DECISION DELEGATED TO HEAD OF PLANNING

Application No:	H16-0654-21	Applicant:	Mr D Pite
Proposal:	Change of use of residential annexe to one C3 private dwelling separate from the host building, including minor alterations to boundary treatments.		
Location:	Jap Lodge, Annexe To Mercia Lodge 65 Pinchbeck Road Spalding		
Terminal Date:	21st August 2022

CASE OFFICER ASSESSMENT

Site Block Plan as proposed.

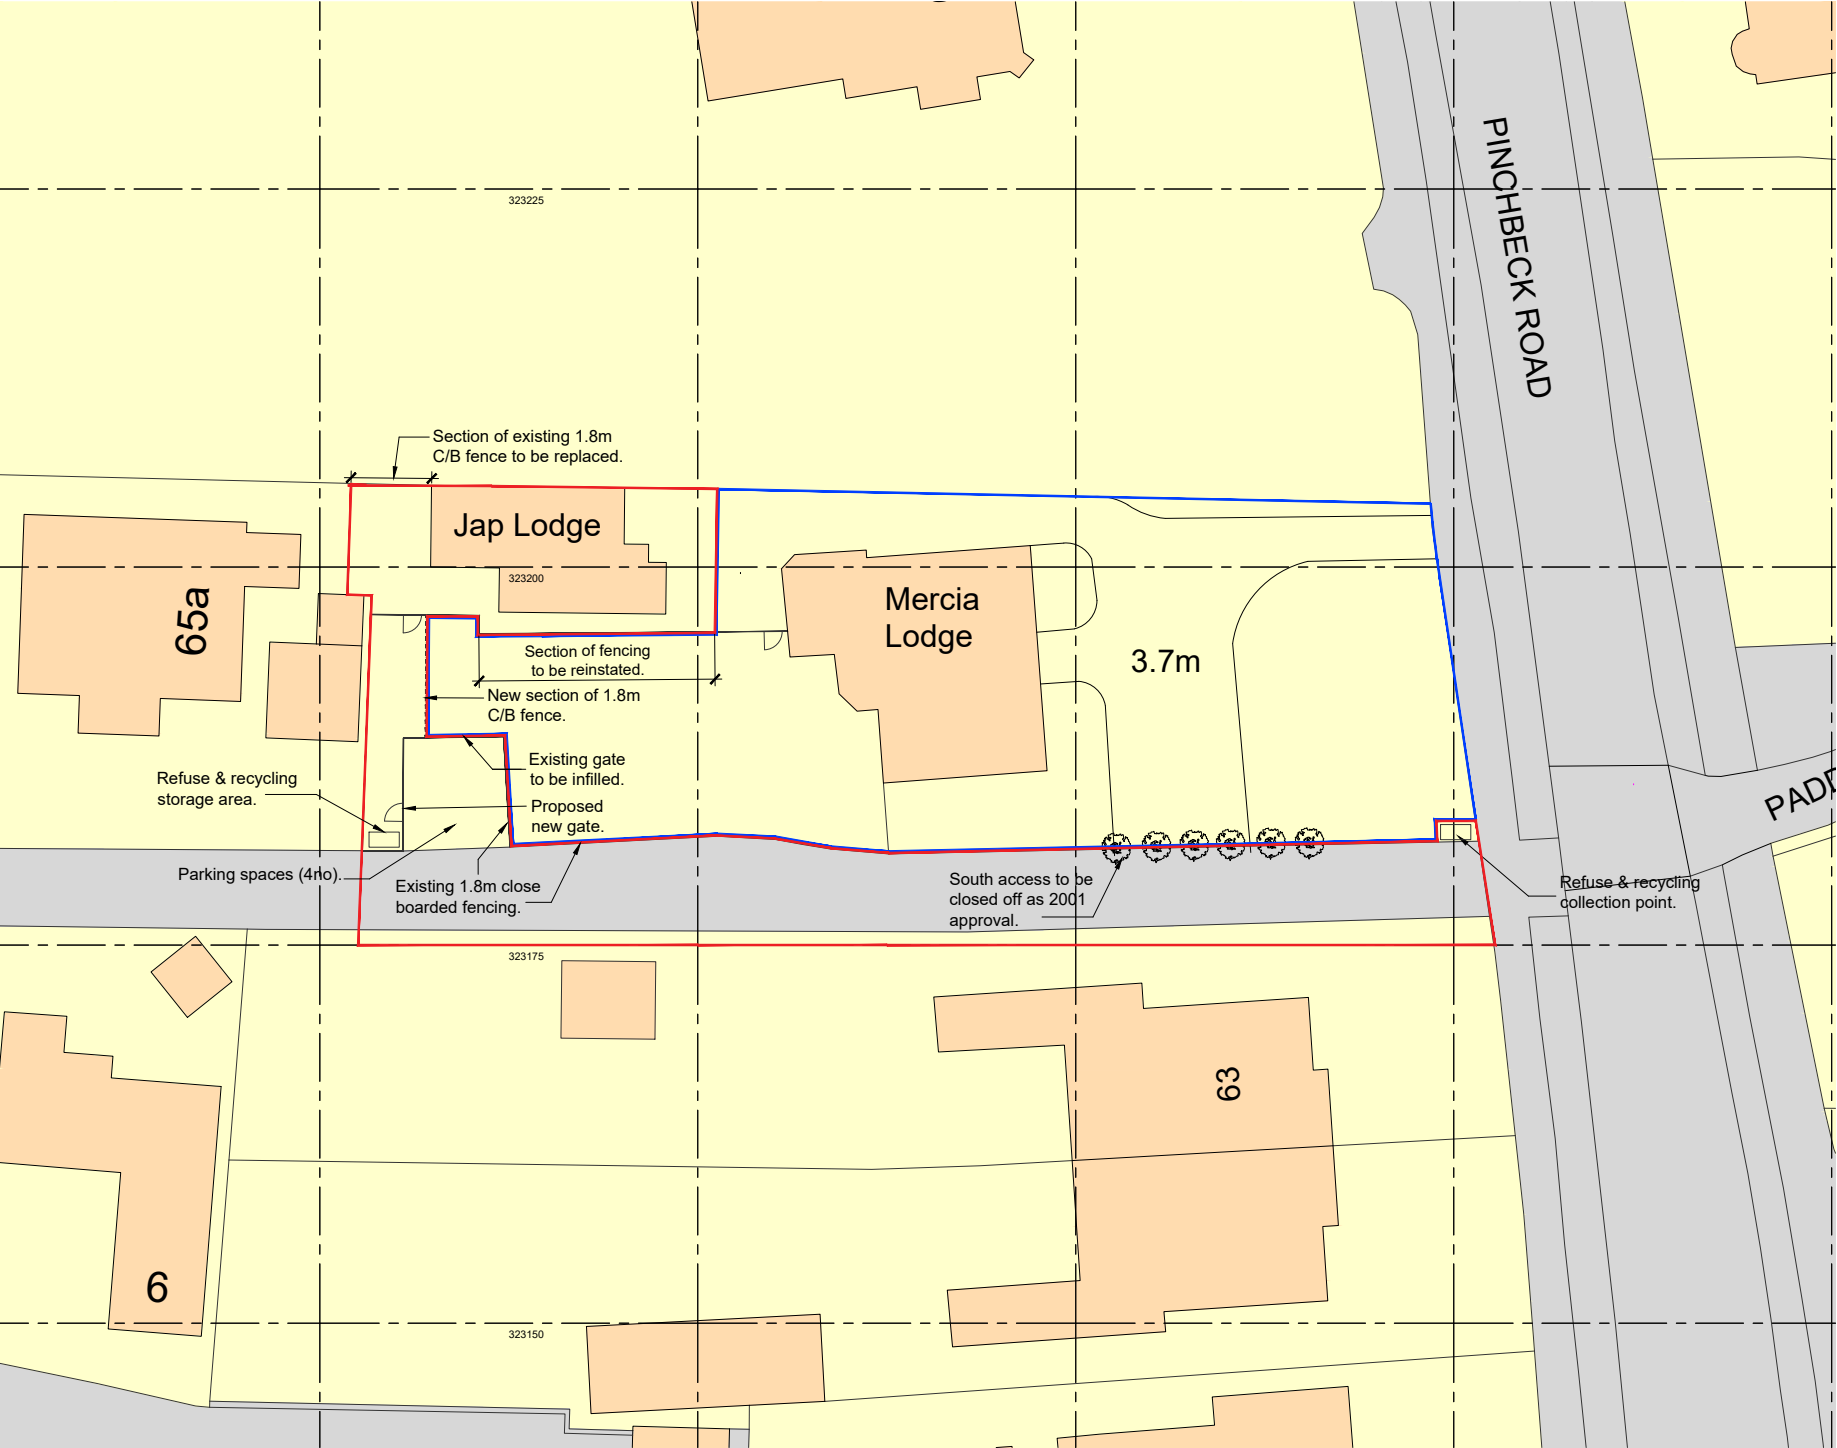
No changes are proposed to the exterior or interior of the Annexe, nor to Mercia Lodge. The alterations to boundary treatments are to enable the physical separation of the boundaries and garden areas of the two buildings (Mercia Lodge and the Annexe), and to enable direct pedestrian access to the vehicle parking area and access on to the lane to the side for the Annexe.

It is considered that the erection of timber fencing and the installation of a pedestrian gate to access the parking area is minor in nature and would not harm the fabric or setting of the listed buildings, and would have a neutral impact upon the character and appearance of this part of the Spalding Conservation Area.

The parking area shown for The Annexe could serve two vehicles comfortably, although it is indicated on the drawings that 4 parking spaces could be provided. Given that this property would be occupied as a C3 dwelling, it is considered that the parking shown is adequate.
